Your Ref	SSD-10349252
Our Ref	NCA/11/2020
Contact	Paul Sartor
Telephone	9806 5740
Email	psartor@cityofparramatta.nsw.gov.au

12 May 2021

COUNCIL SUBMISSION

NOTICE OF EXHIBITION OF ENVIRONMENTAL IMPACT STATEMENT FOR PAEDIATRIC SERVICES BUILDING AT THE CHILDREN'S HOSPITAL AT WESTMEAD (CORNER OF HAWKESBURY ROAD AND HAINSWORTH STREET, WESTMEAD)

ATTACHMENT C
**LOADING DOCK HRV (SIDE-
LOADING) BAY SWEEP PATH**

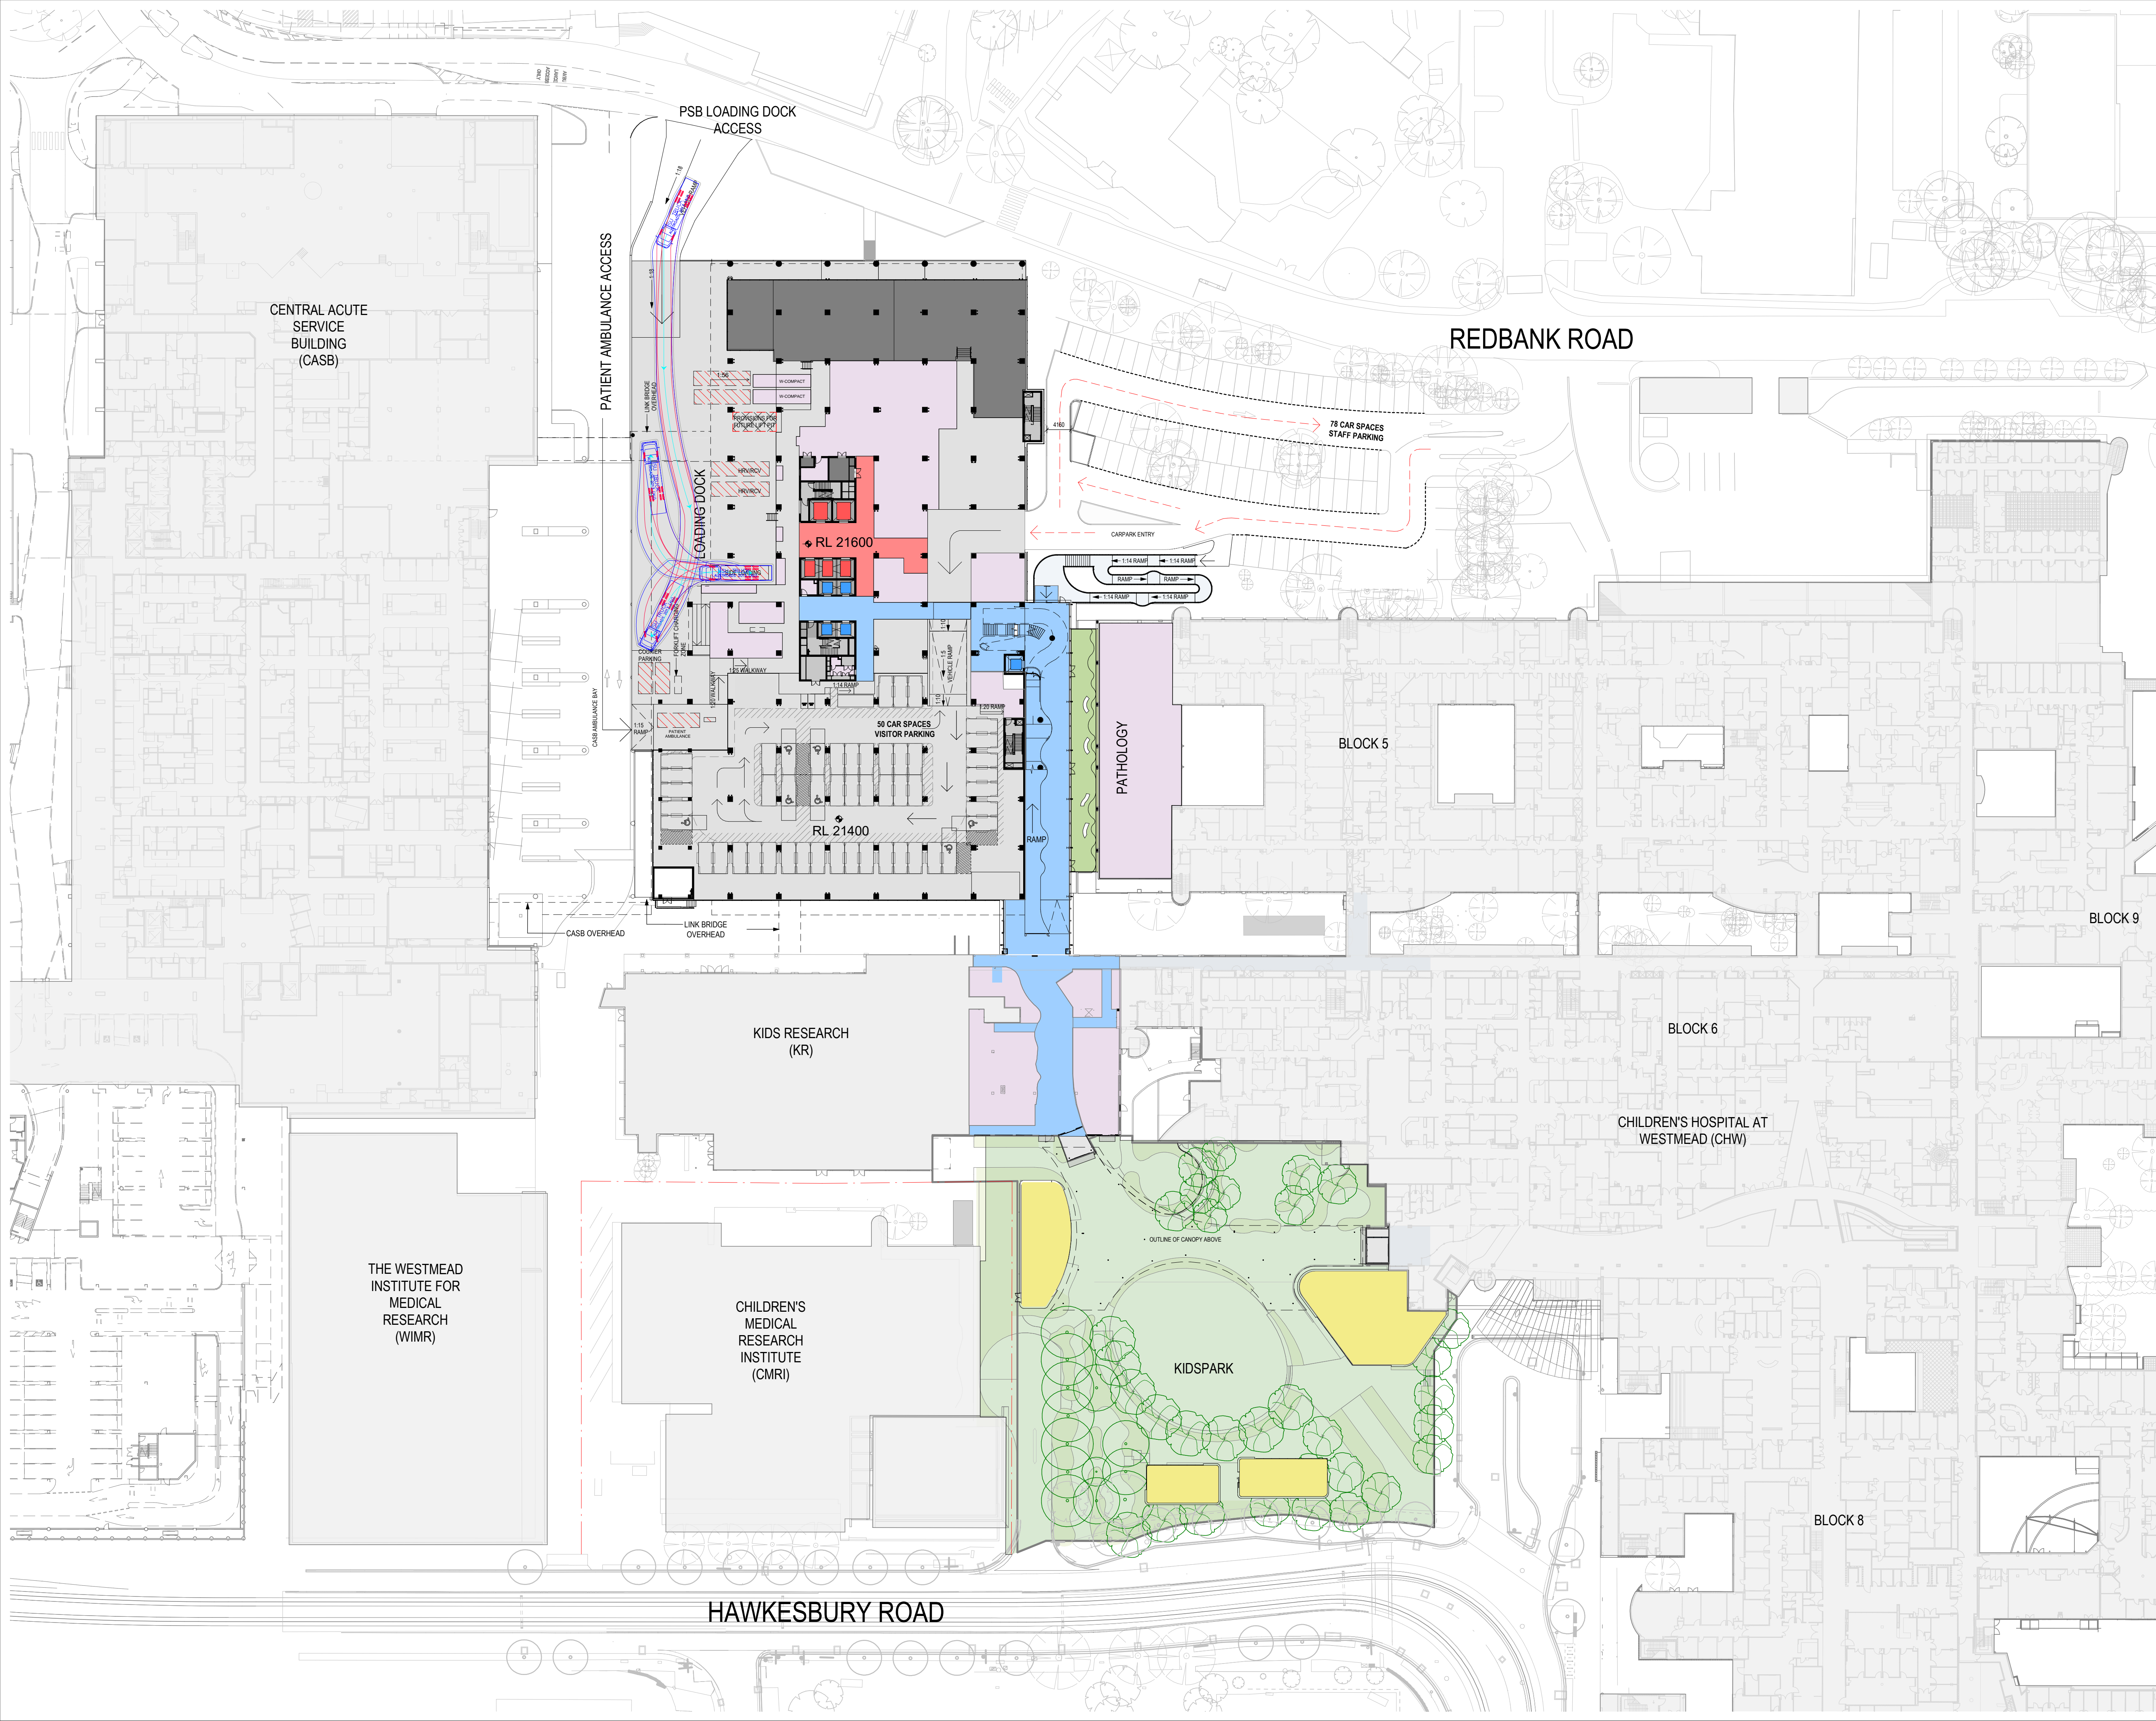
- Swept path plans for the loading dock have been provided and indicate that on-site manoeuvring for vehicles accessing the HRV, Substation Maintenance bays and Compactor bays require certain spaces to be unoccupied and at times, utilise the full width of the driveway/ramp in order to park the vehicle rear to kerb. It is unclear how the spaces will remain unoccupied, how the trucks will be coordinated within the loading dock and who will have priority should there be vehicles (particularly HRVs) wanting to enter and exit the facility simultaneously. Therefore, a Loading Dock Management Plan should be provided and reviewed to address these concerns.

ATTACHMENT D
LATEST ARCHITECTURAL
PLAN SHOWING DRIVEWAY
AND RAMP GRADIENTS

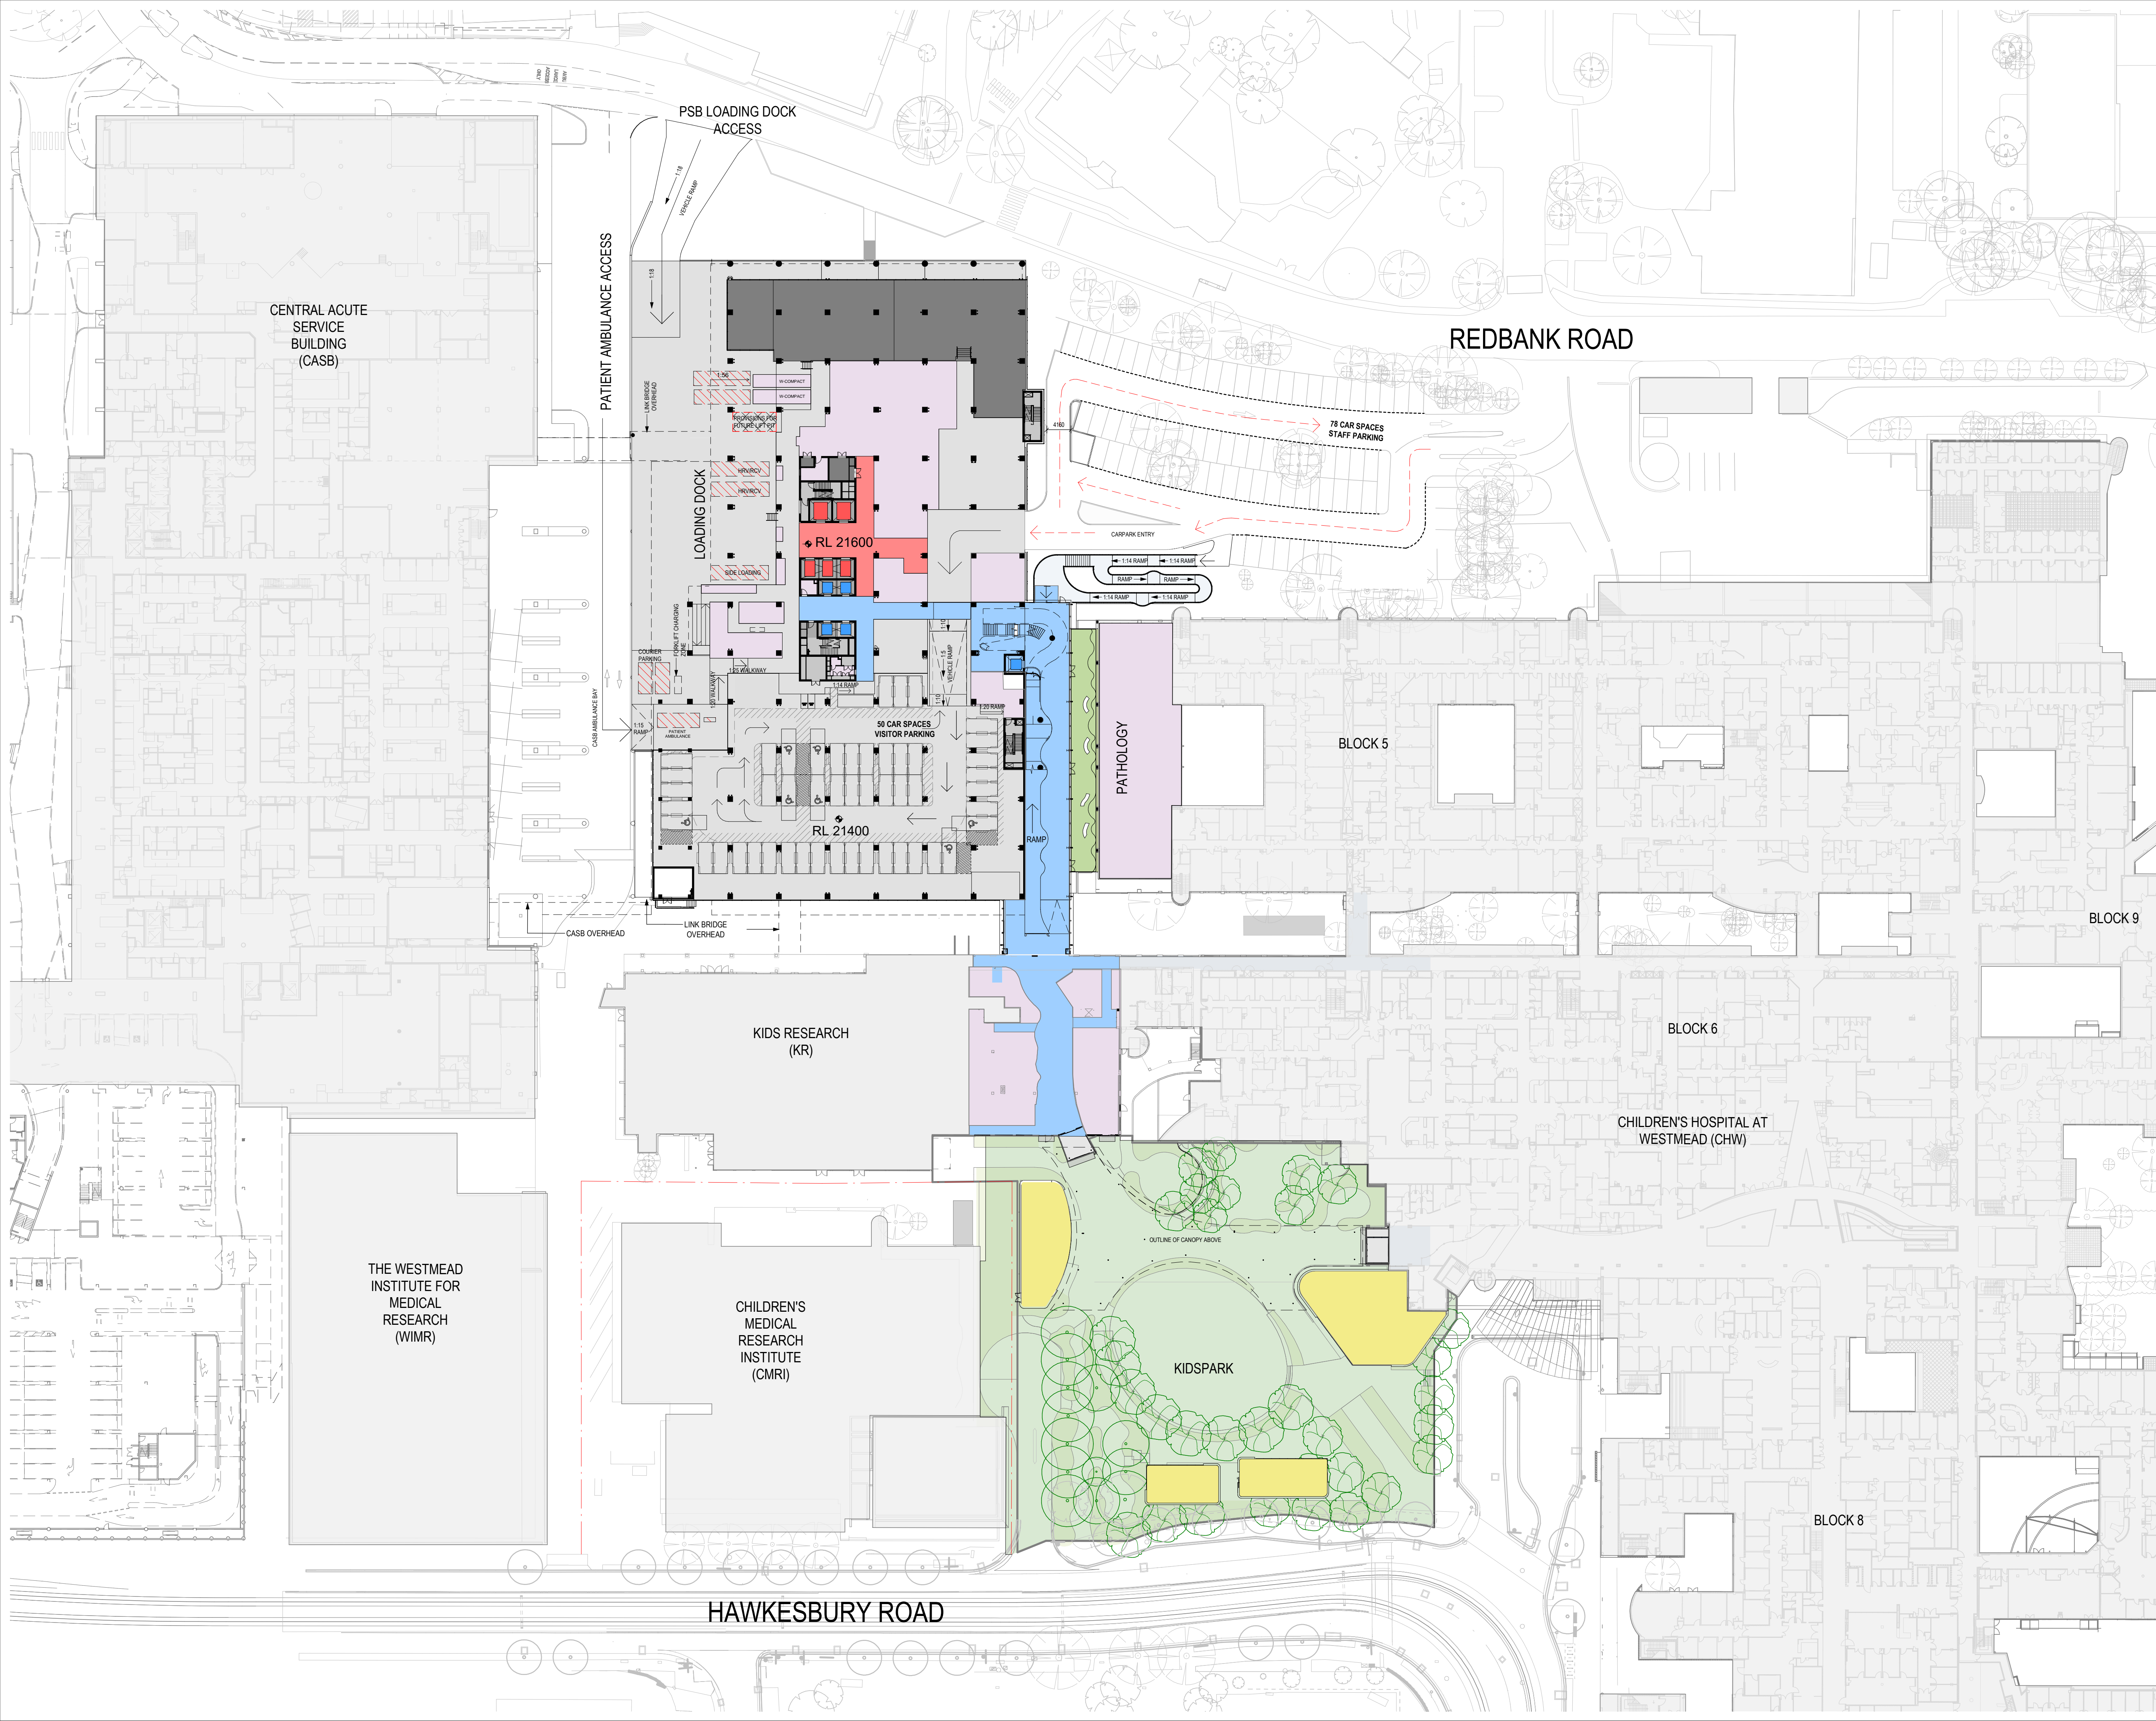
- Driveway and ramp gradients for both the PSB carpark and Loading Dock have not been provided and cannot be peer reviewed.
- The car park design including parking dimensions, aisle widths, column locations, swept paths and sight lines are to comply with AS2890.1
